Please find attached dwg showing the Temporary Haul Road in more detail. Responses to points below in red:

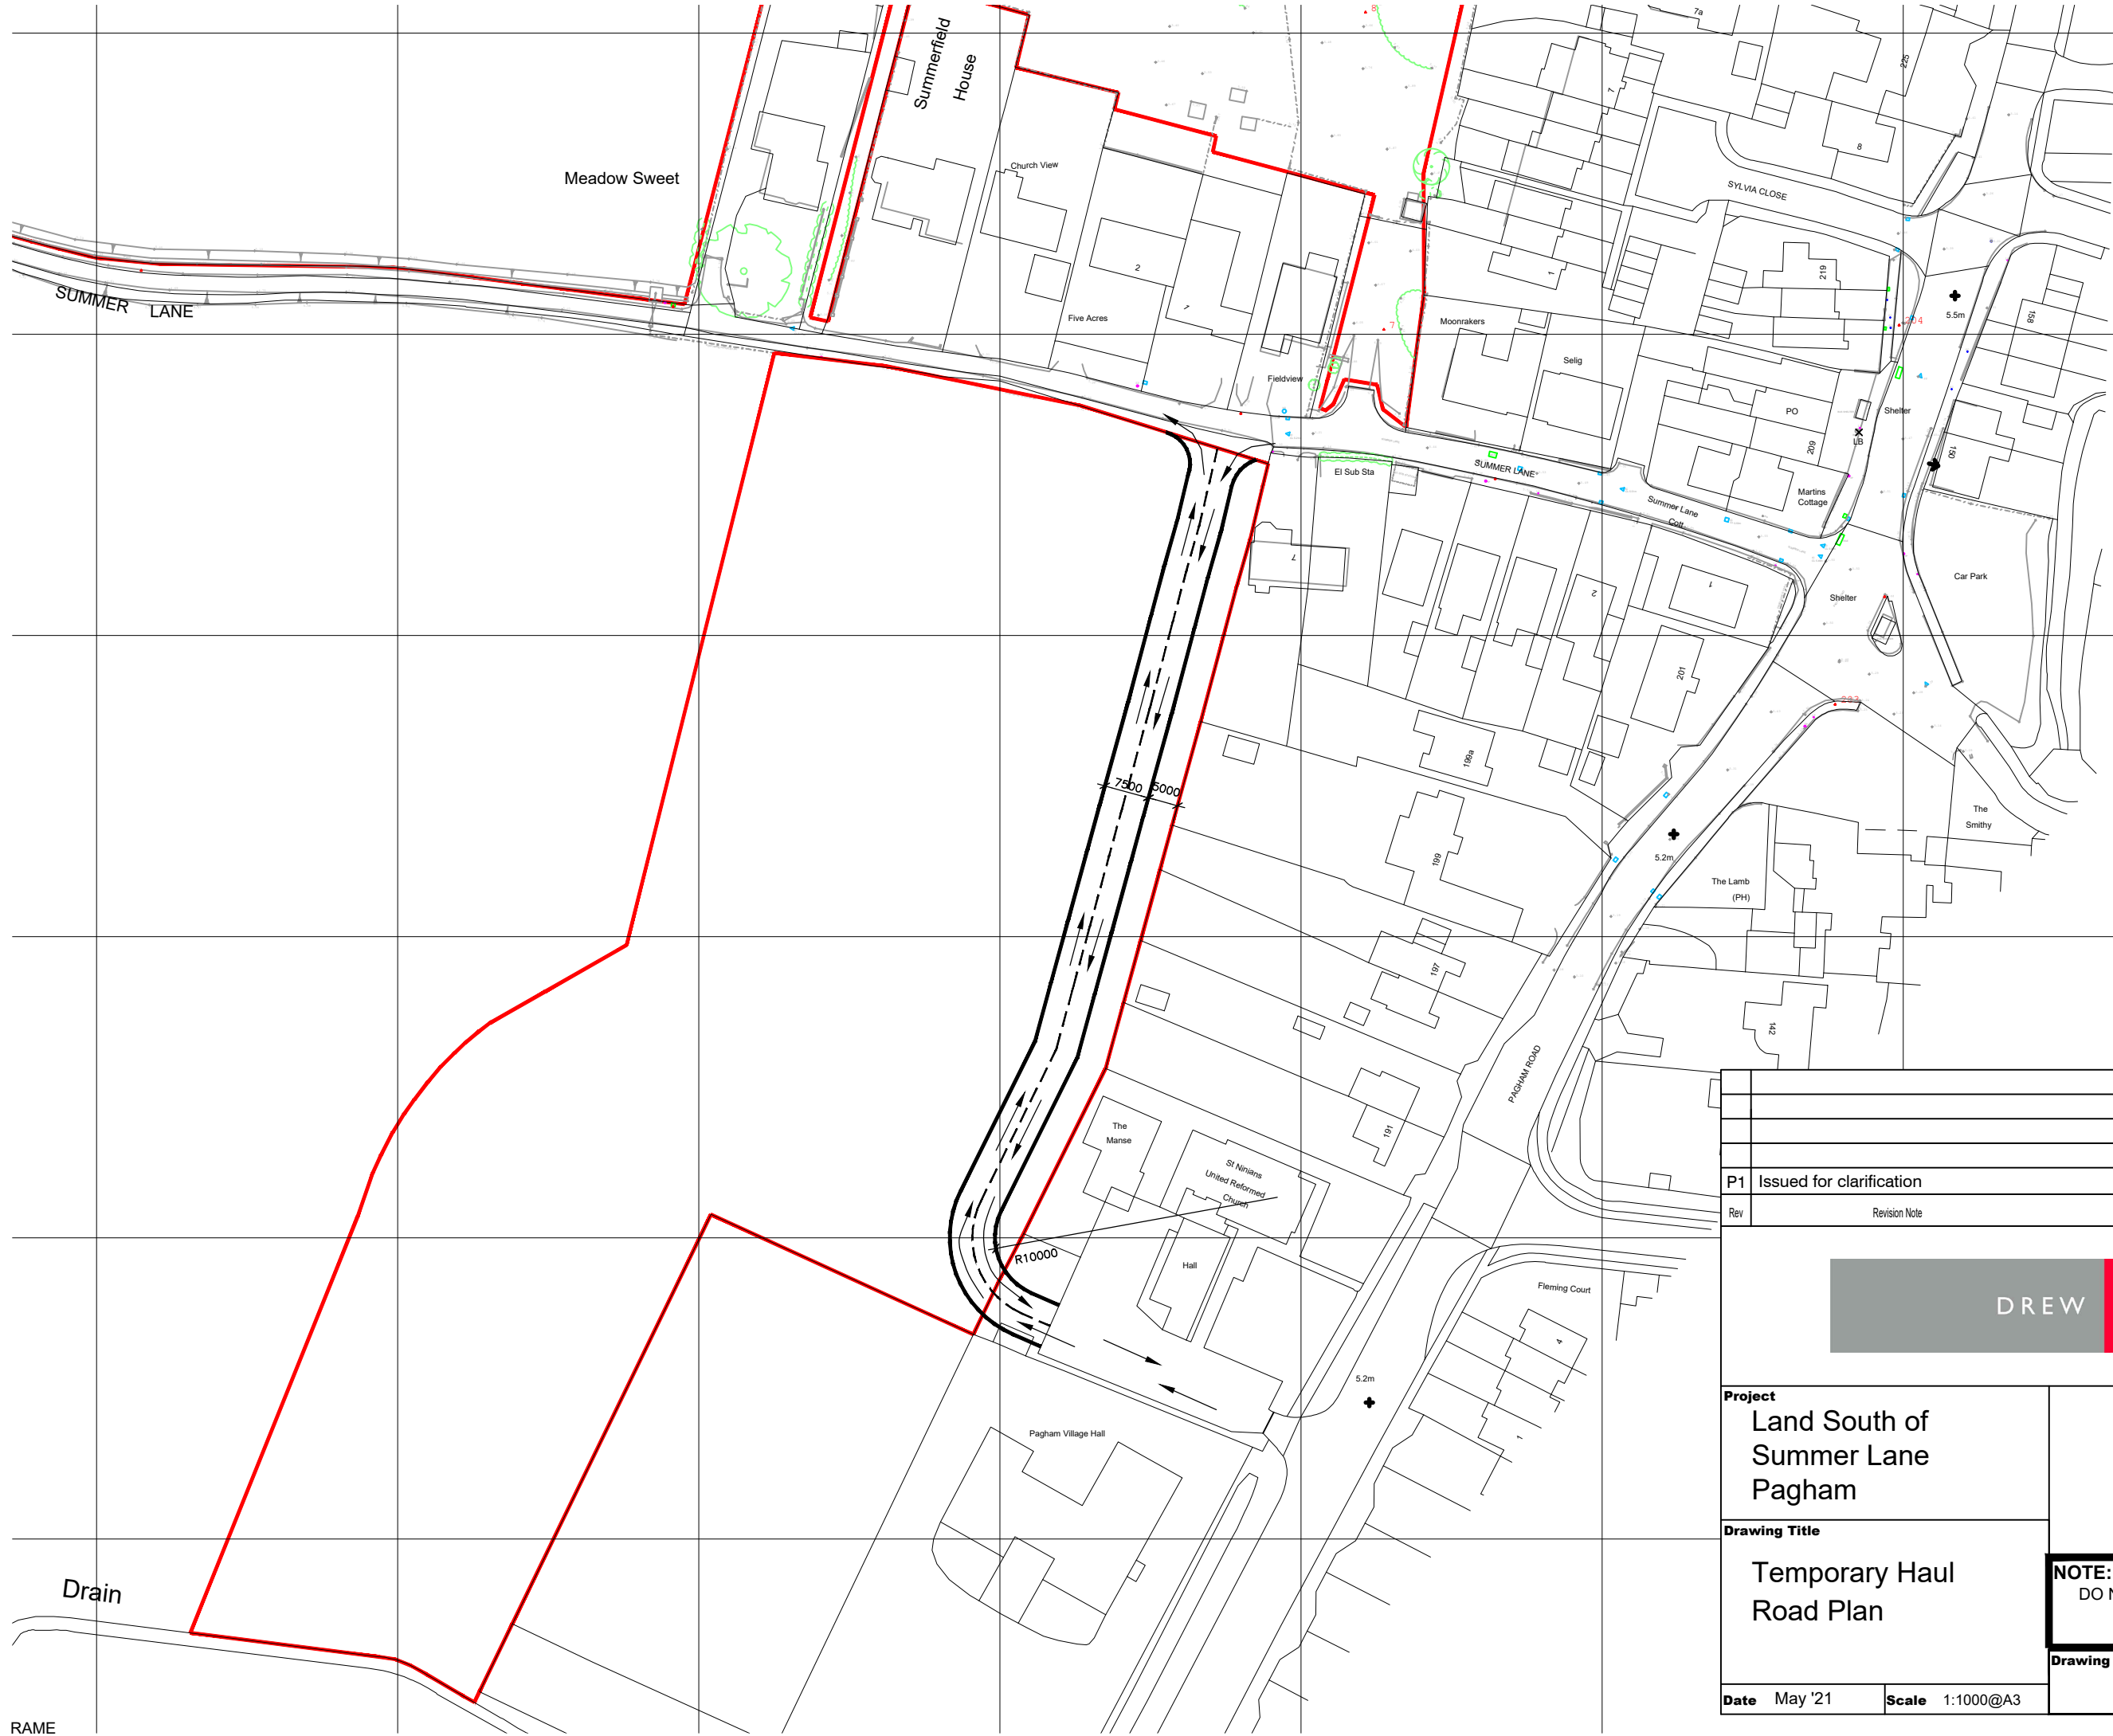
Thanks for your email. I have had a call from a resident of Pagham Road this morning. The person accepted the reason for the road but wanted to know what the road surface will be - Tarmac, whether it will be one or two way -- Two way, what will the exact line of the road be/how far will it be from fences -- 5 metres and how long will it be required for? -- 12 months from opening Are you able to provide some of this information so that I can relay it to residents.
